From: kirtlingtonclerk@gmail.com
Sent: 17 April 2023 18:42
To: Gemma Magnuson
Cc: Planning
Subject: 23/00750/TEL56 - Station Road Kirtlington, Proposed 15.0m Phase 9 slimline Monopole and associated ancillary works - comments from Kirtlington Parish Council
Attachments: 21-03452-TEL56 PINS 3290284 Appeal Decision 15Feb2023.pdf; 23-00750-TEL56 Junction approach Conservation Area.heic; 23-00750-TEL56 Verge and stone wall.heic; 23-00750-TEL56 View southwards.heic; 23-00750-TEL56 Kirtlington Parish Council response.pdf

**23/00750/TEL56 - Street Record Station Road Kirtlington
Proposed telecommunications installation: Proposed 15.0m Phase 9 slimline Monopole and associated ancillary works**

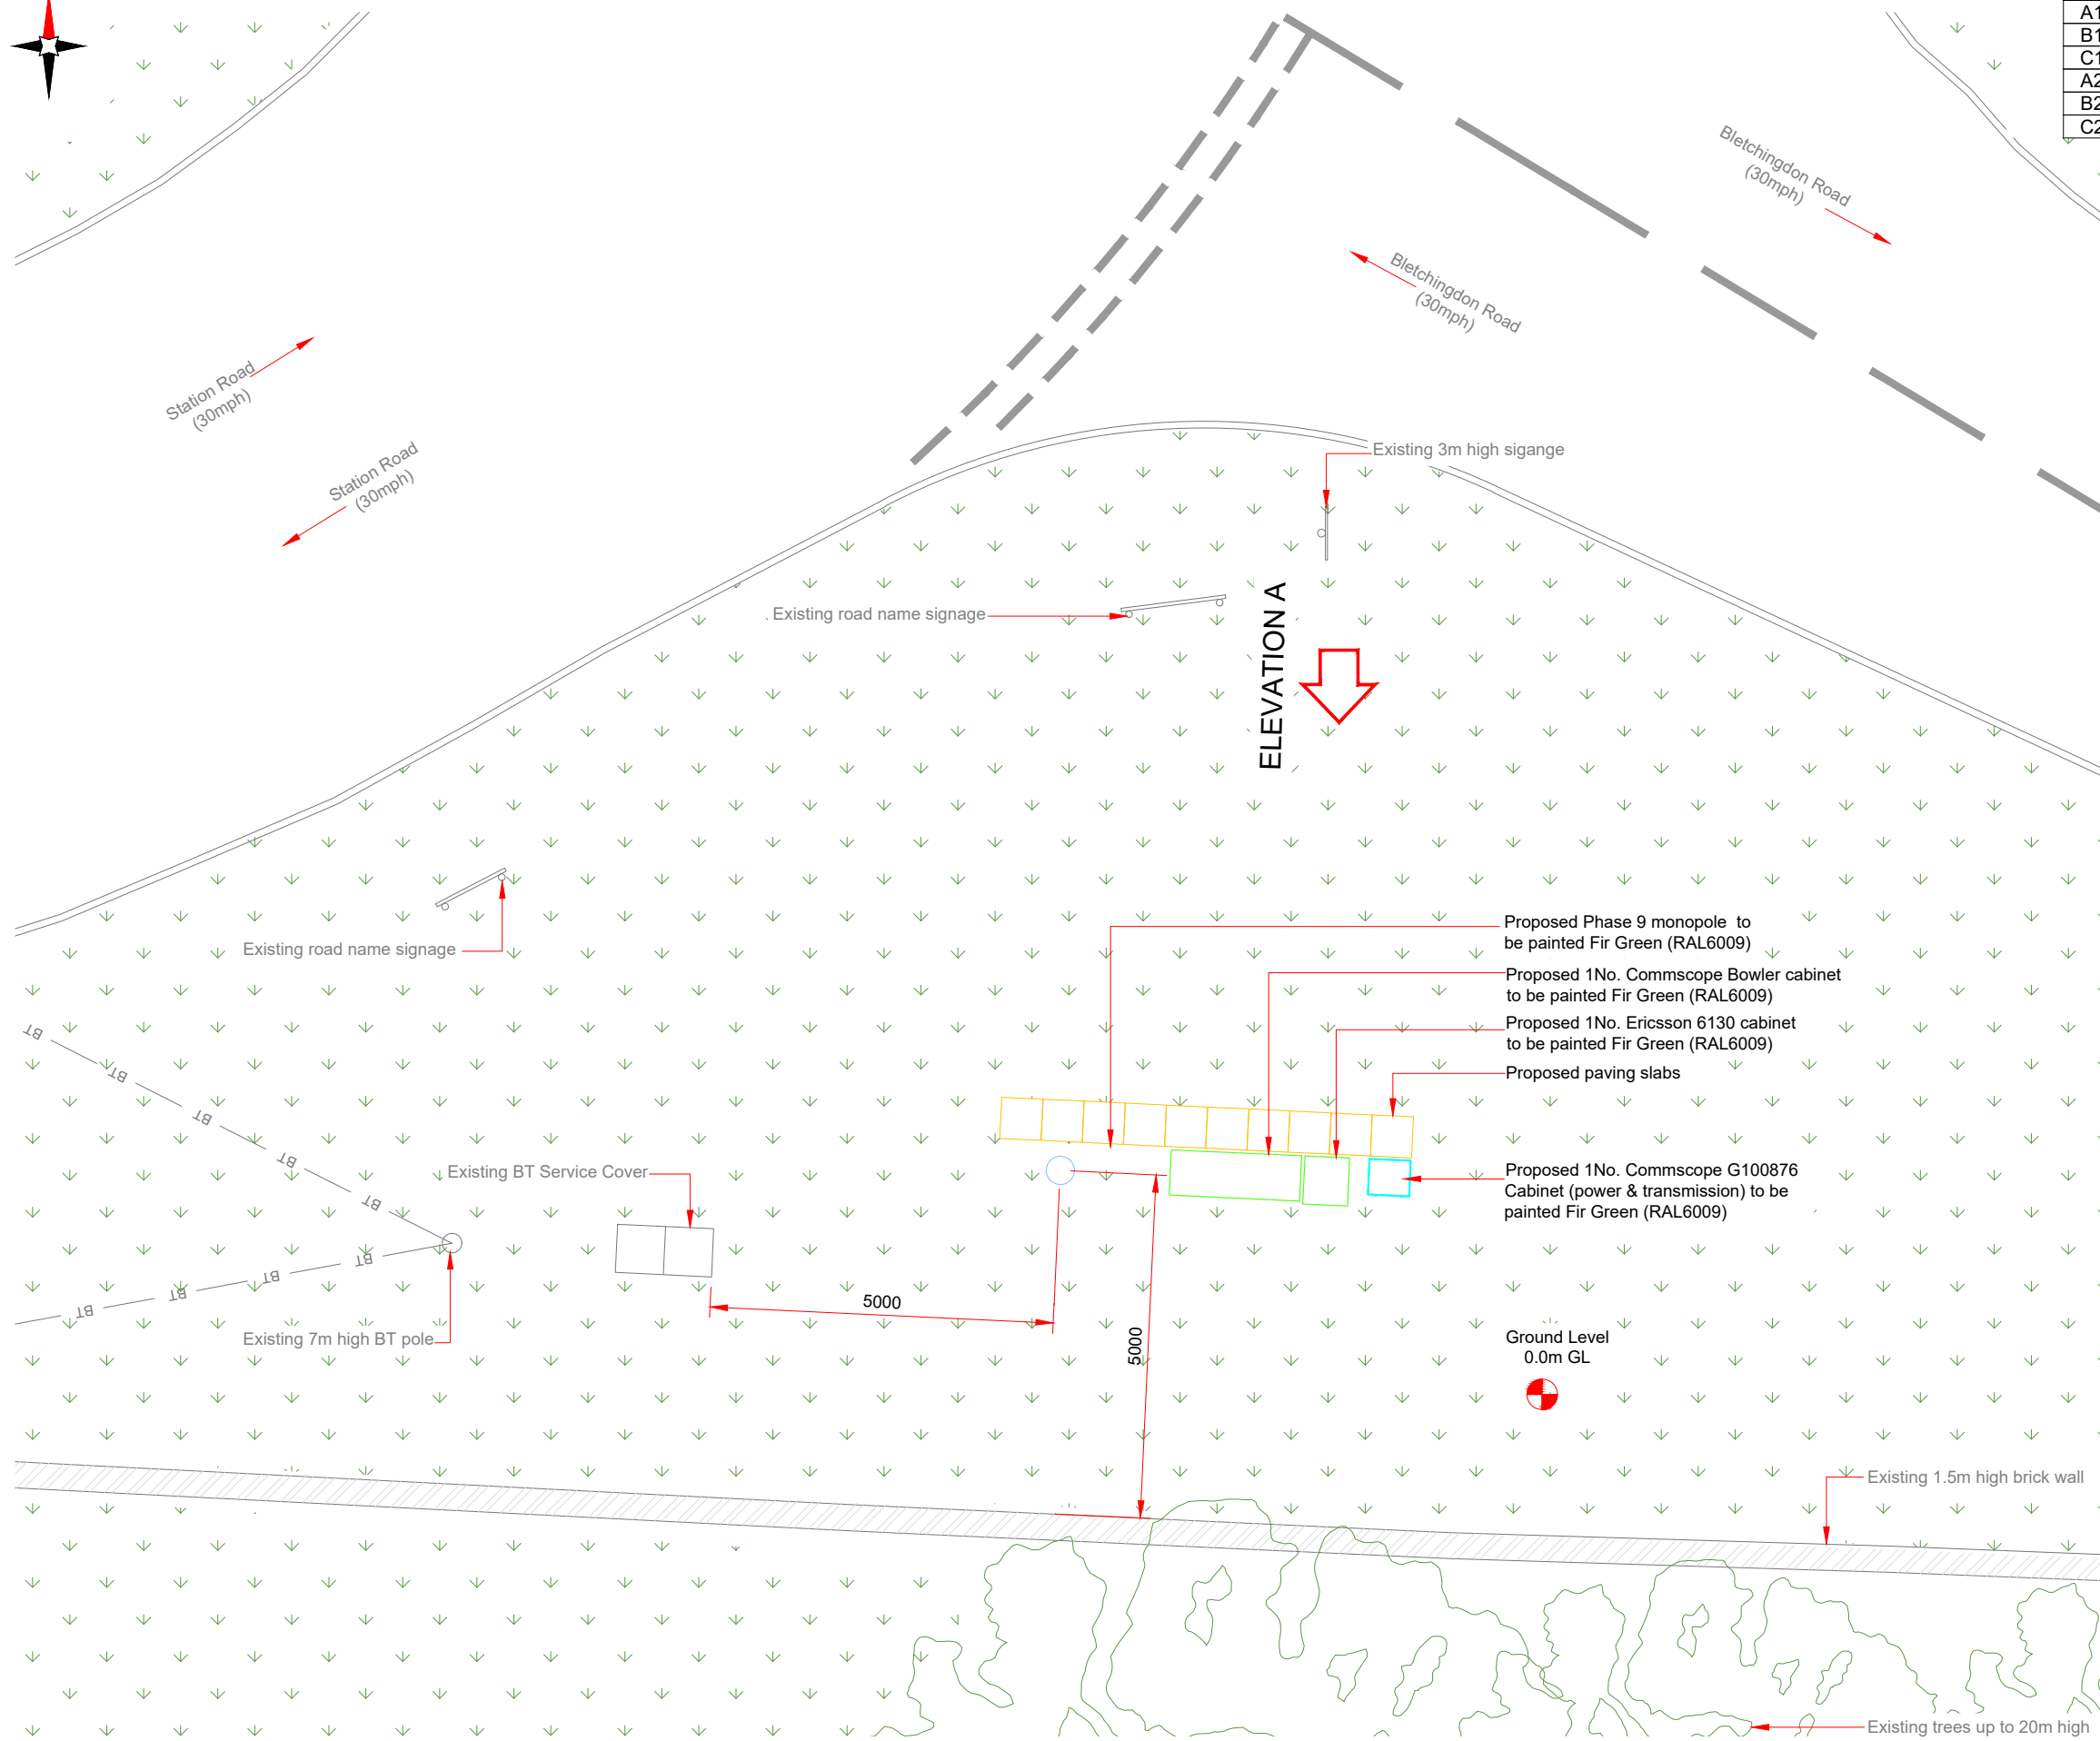
"The site selection process has also been influenced by the numerous vertical elements of street furniture distributed around the vicinity of the site including street lighting columns." There is no street lighting in this part of Kirtlington. *"The mast will be mounted on a wide grass verge adjacent to Station Road to avoid impeding on pedestrian flow and to allow pedestrians to maintain unrestricted access to the footpath."* There is no pedestrian footpath here, just an uninterrupted view across open countryside.

"To the rear of the mast is existing street furniture (utility pole) which shares a similar vertical column to the mast; and a brick wall with similar height and structure to the cabinets, supporting both mast and cabinets in assimilating into the setting". There is a single 7m high BT pole which would be dwarfed by the 15m monopole. The wall behind is not brick but a low-level dry-stone wall which has a positive impact on the heritage asset and is itself considered to be a non designated heritage asset. This would be obscured by the cabinets.

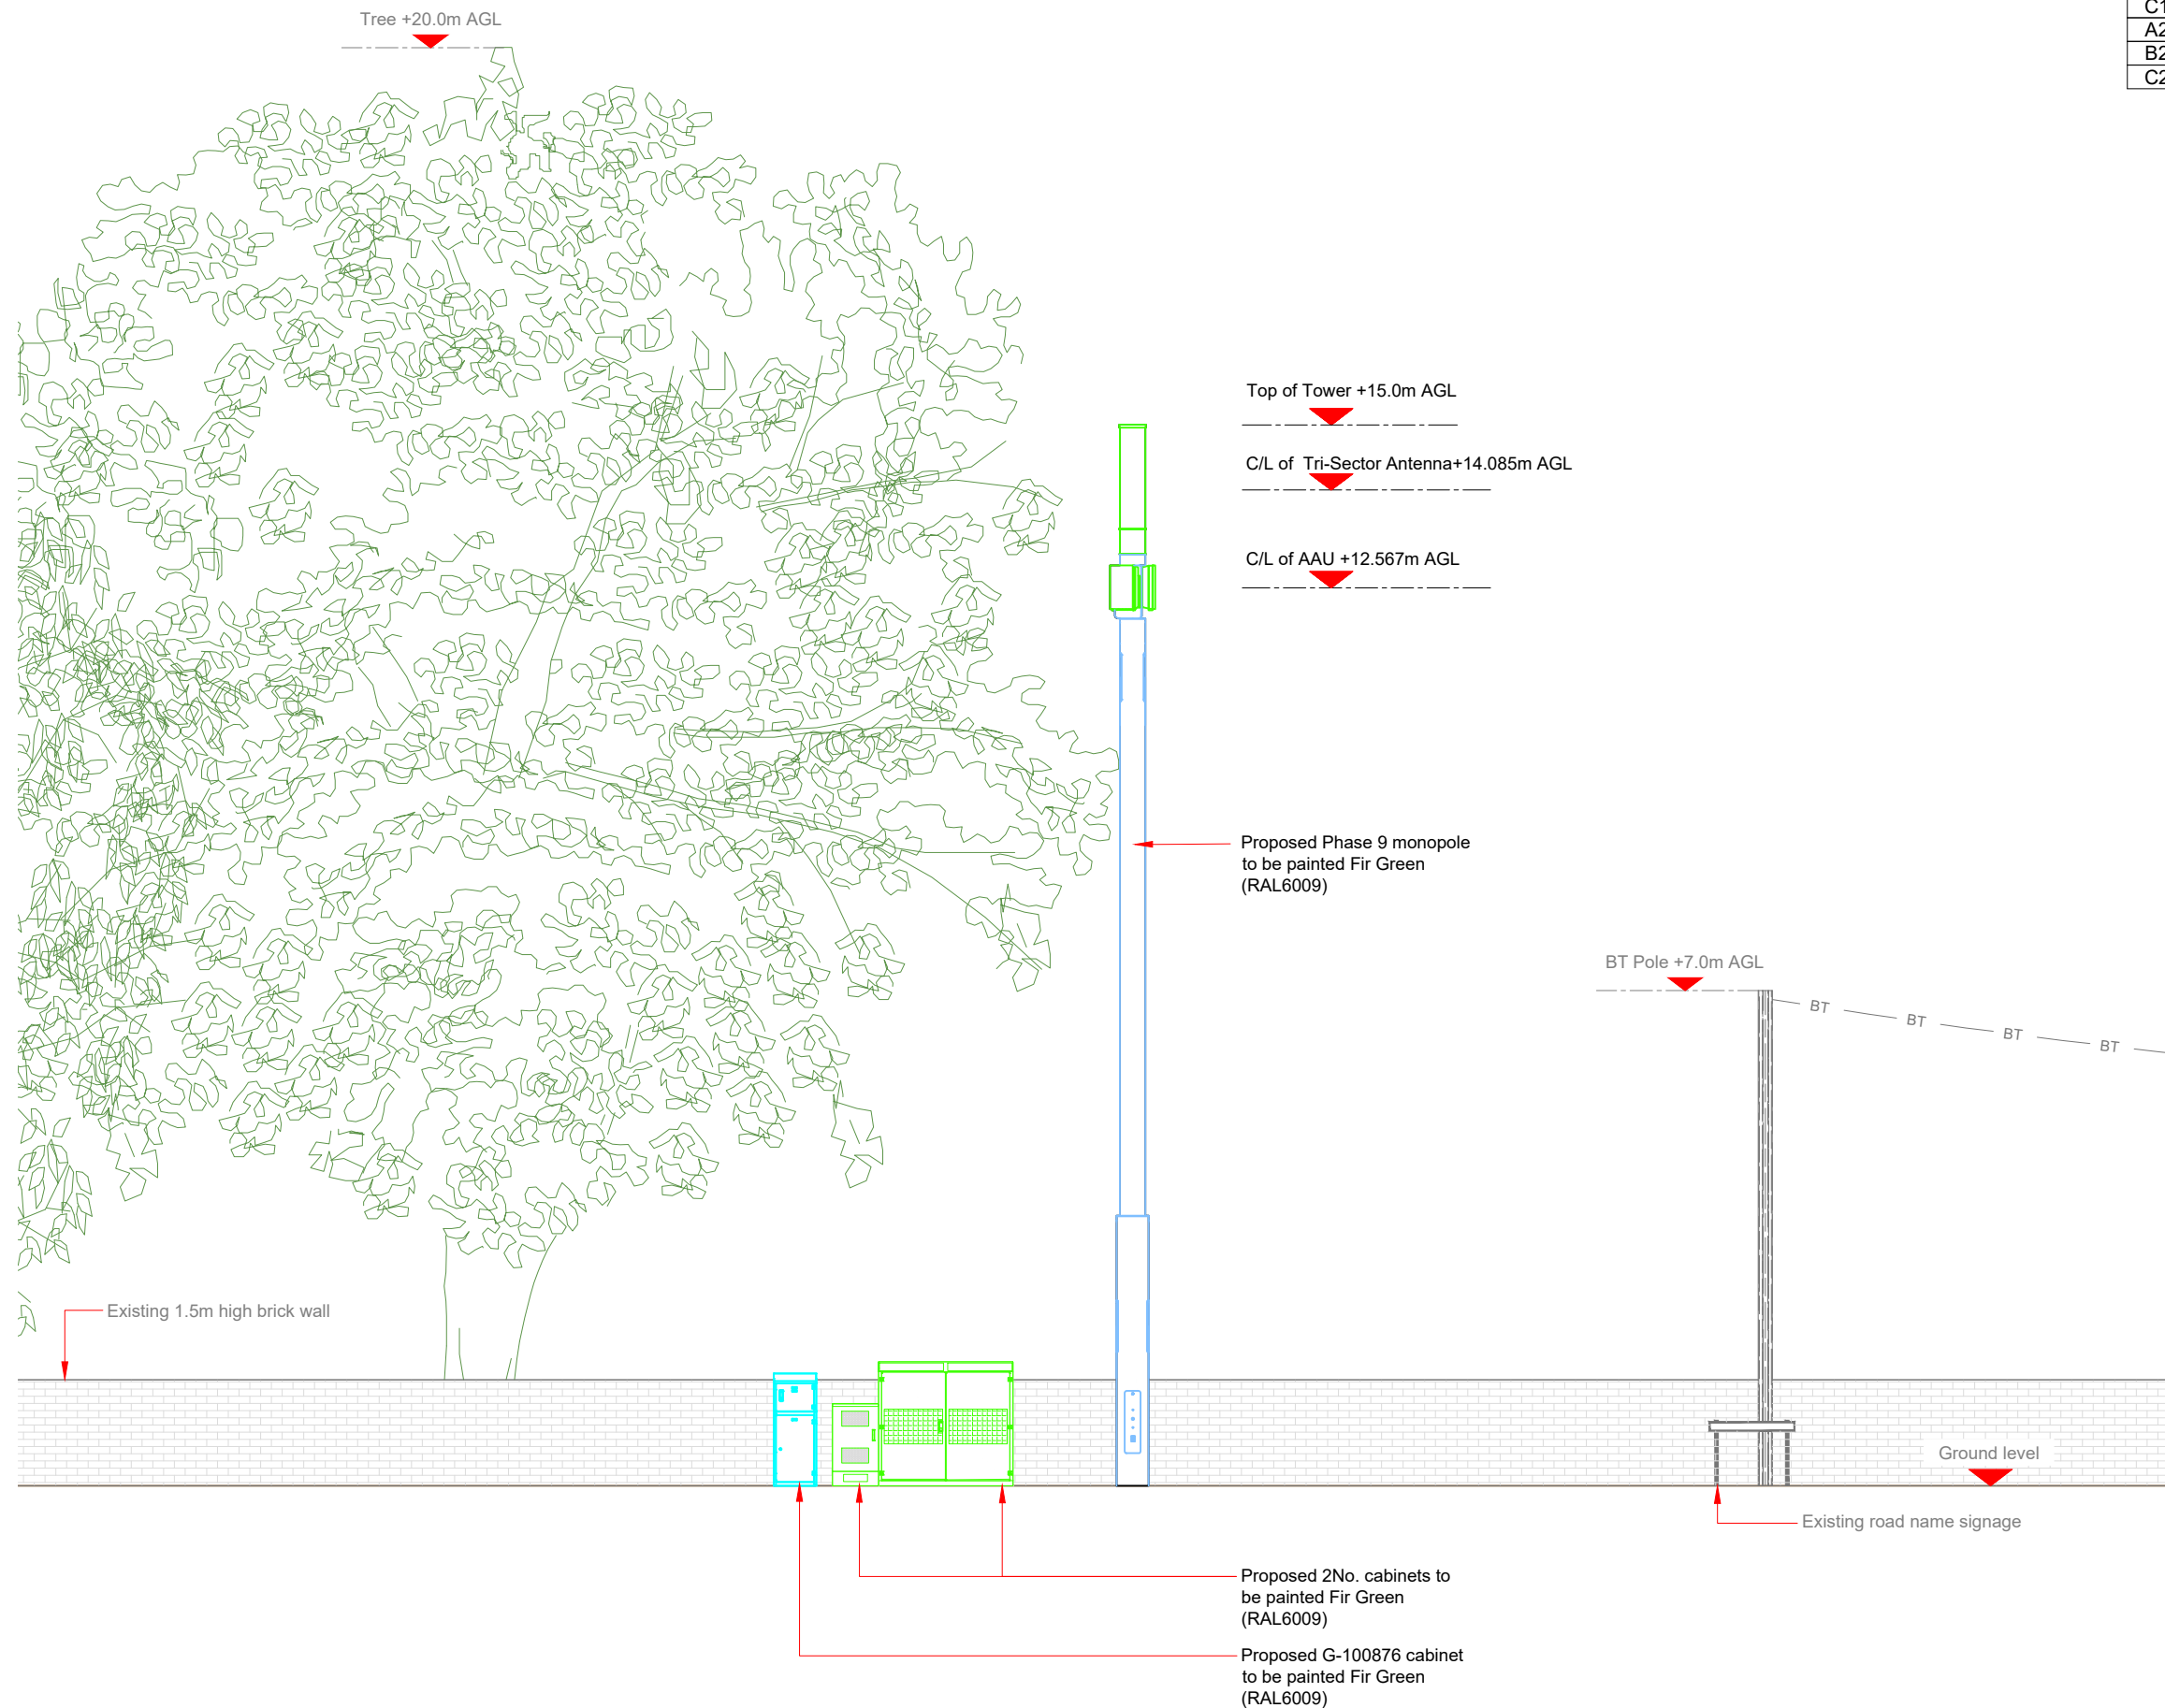
visual impact upon the street scene by integrating with the existing street furniture, having similar vertical lines and overall appearance to the numerous street lighting columns in this area". Again, please refer to photographs and confirm that there is no street lighting in this part of the village.
